Re: Planning Application 2021/94607

48 Hill Grove, Salendine Nook, Huddersfield

FRONT ELEVATION 1 :50

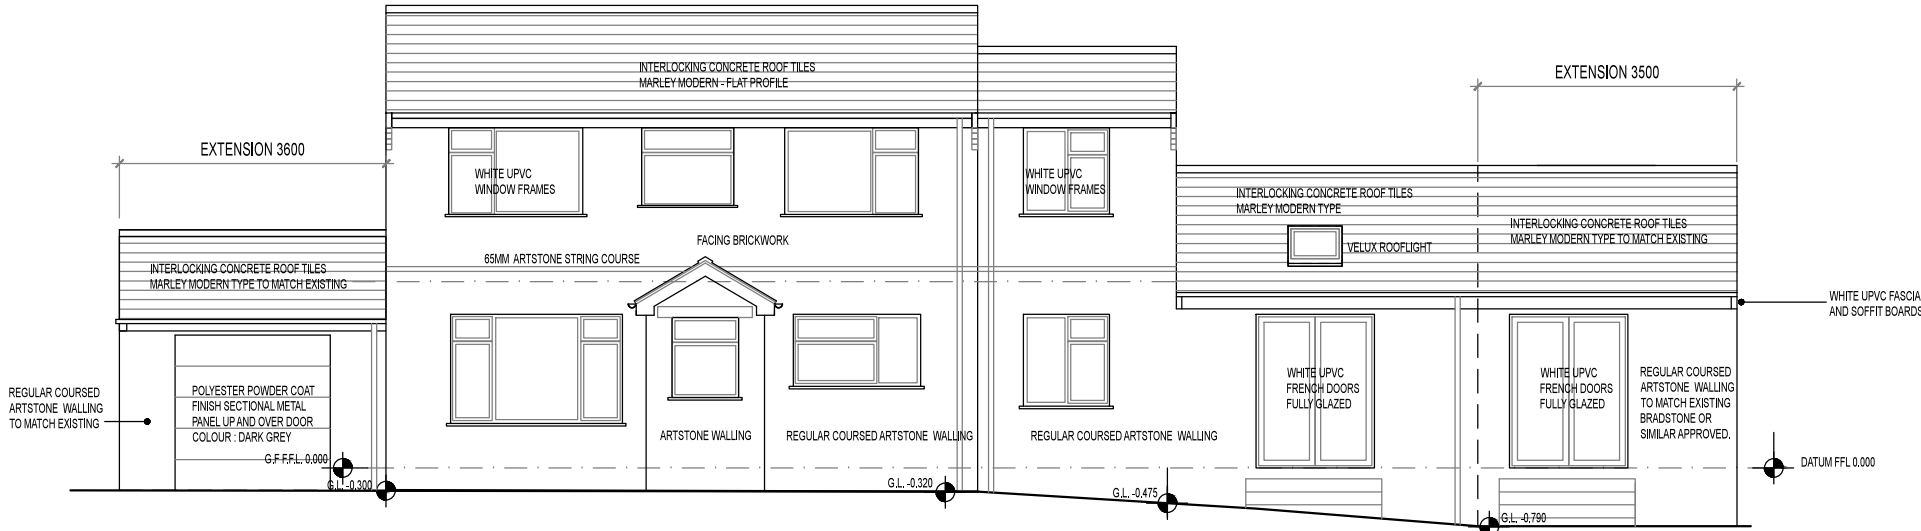
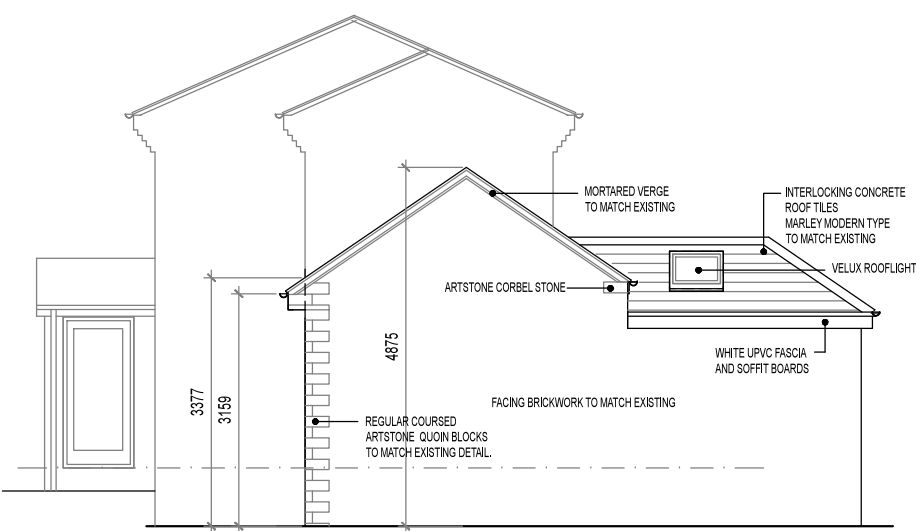
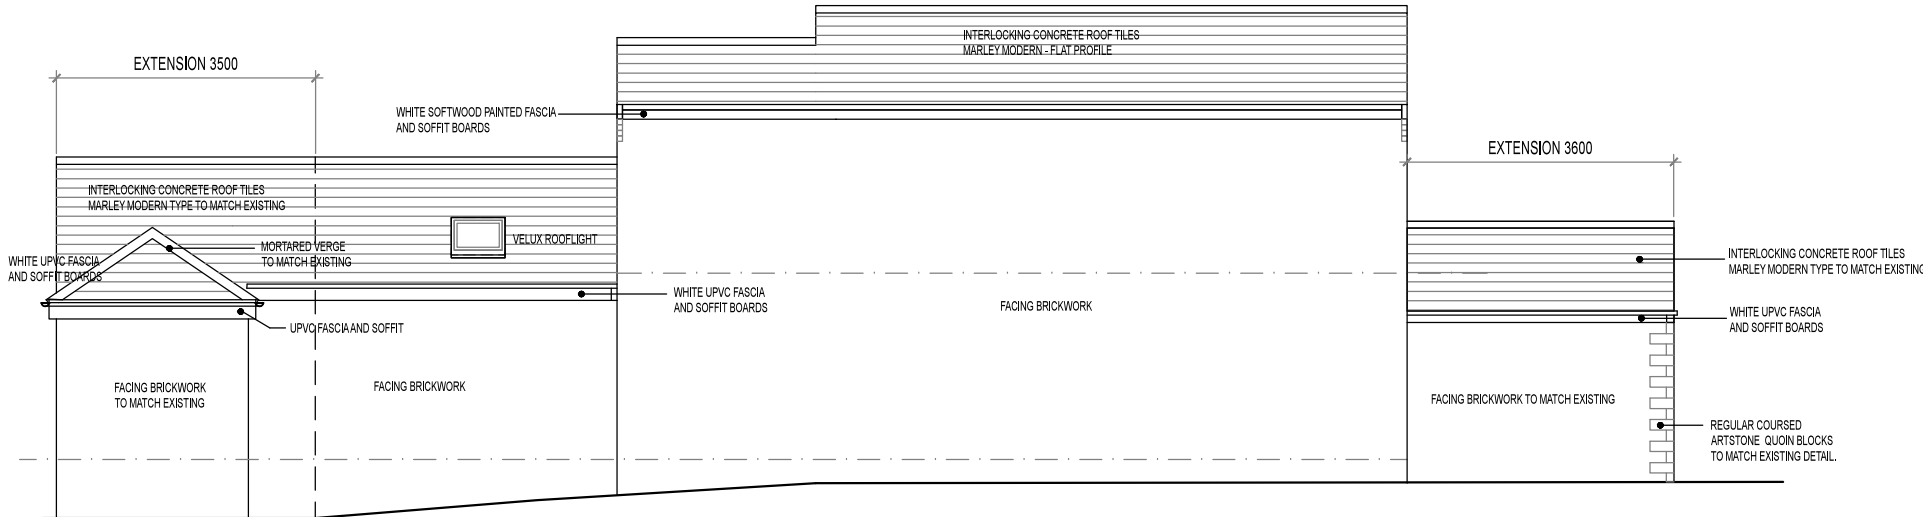
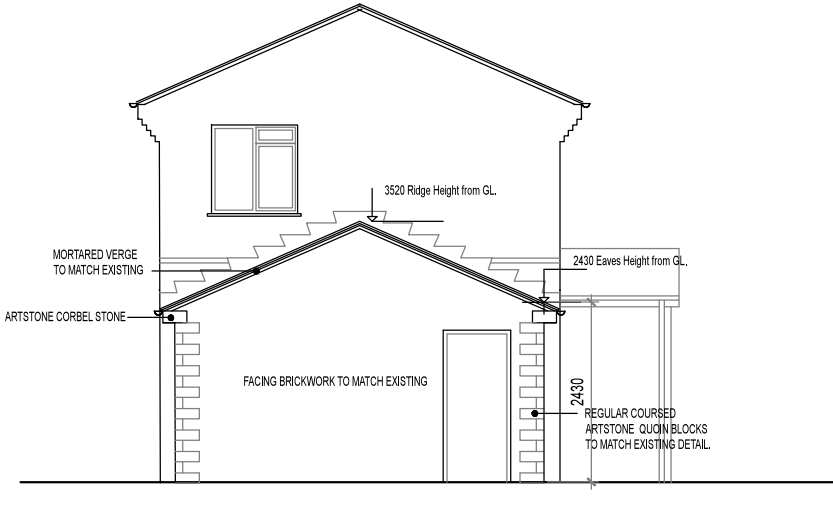
3. The existing house has a relatively balanced facade, this detail which is shared by neighbouring houses, will be unnecessarily vandalised by the extension characteristics.

4. The existing properties have a sense of balance and composition. This proposal utterly ignores the original building scale and composition. There is no attempt to harmonise or even add to the existing house in a sympathetic manner which respects both the existing house and the neighbourhood. The front elevation of the proposed building displays two sets of French doors in addition to the front door, giving the appearance of a House of Multiply Occupancy. This proposal is not a neighbourly building.

SITE PLAN 1 : 100

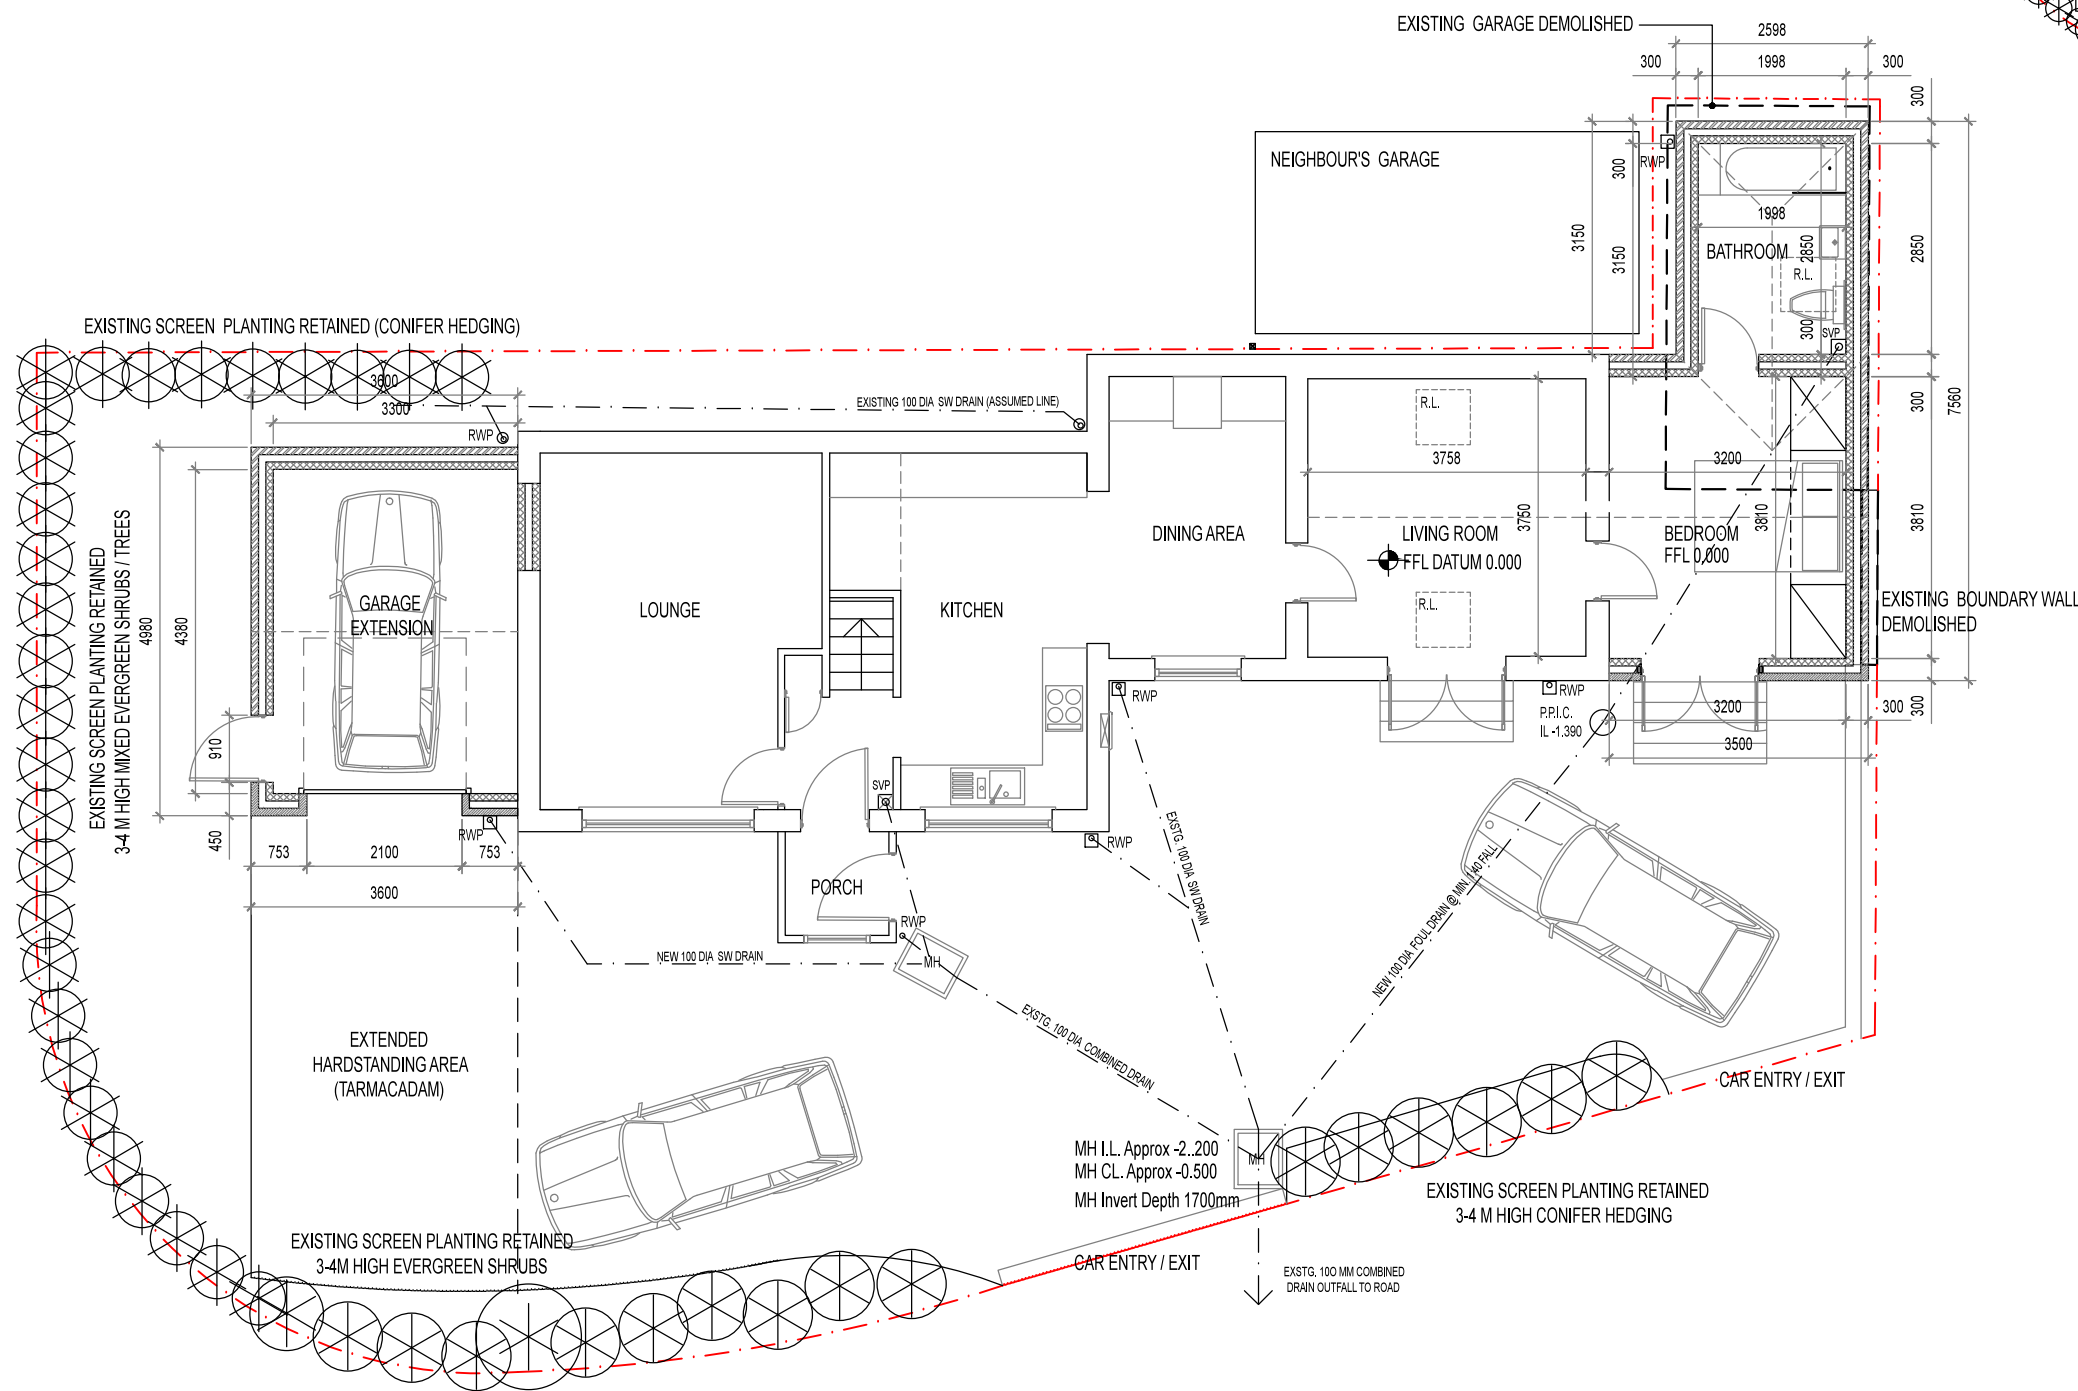
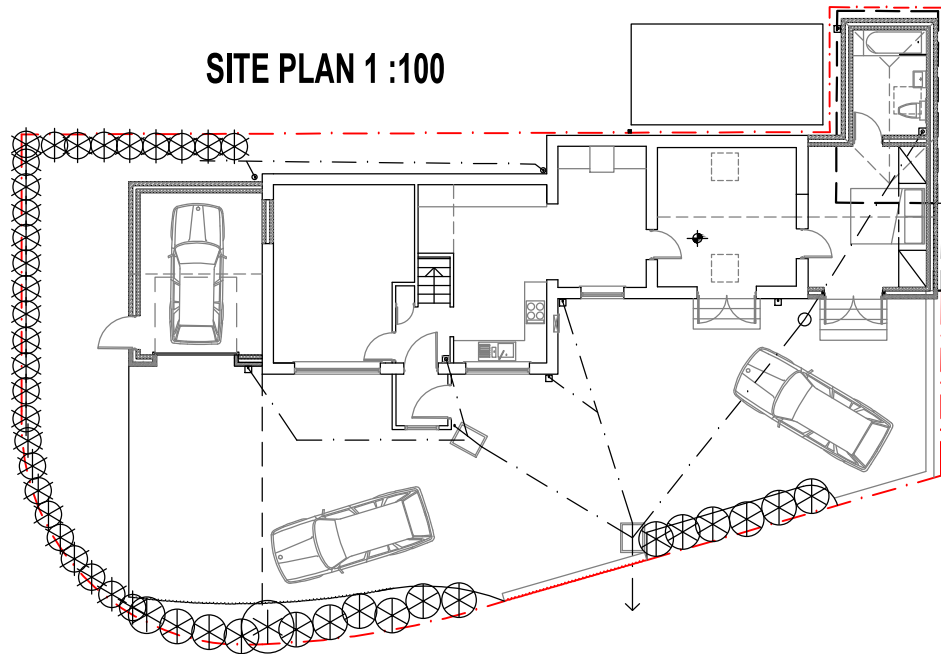
1. The proposed extension to #48 will leave no space in three sides.
2. The proposed extension would destroy the essential qualities of the locality. The estate consists of regular, rectangular, well proportioned properties and this proposal ignores these qualities by creating a misshapen ill proportioned building mass, the estate is made up of houses where the short elevation faces the street, this proposal would create another wide house, out of character with the originals.

8. The 'existing Green Planting Retained (Conifer Hedging)' was planted on our boundary and is not maintained by the occupants of No.48 but by ourselves. The said hedge obstructs the view of the pavement when exiting our driveway and requires somebody to stand at the top of drive to warn pedestrians coming around the corner of the fact that a vehicle is exiting. This represents a Health & Safety Hazard. We have previously requested the reduction in height of the Conifers and this did not meet with the property owners.

9. The plans indicate the tarmac/paving of the property, front, side and the building on all sides to the edges of the property, we feel that this will cause water/rain/snow run-off onto our property as well as onto #46, causing both properties to become waterlogged.
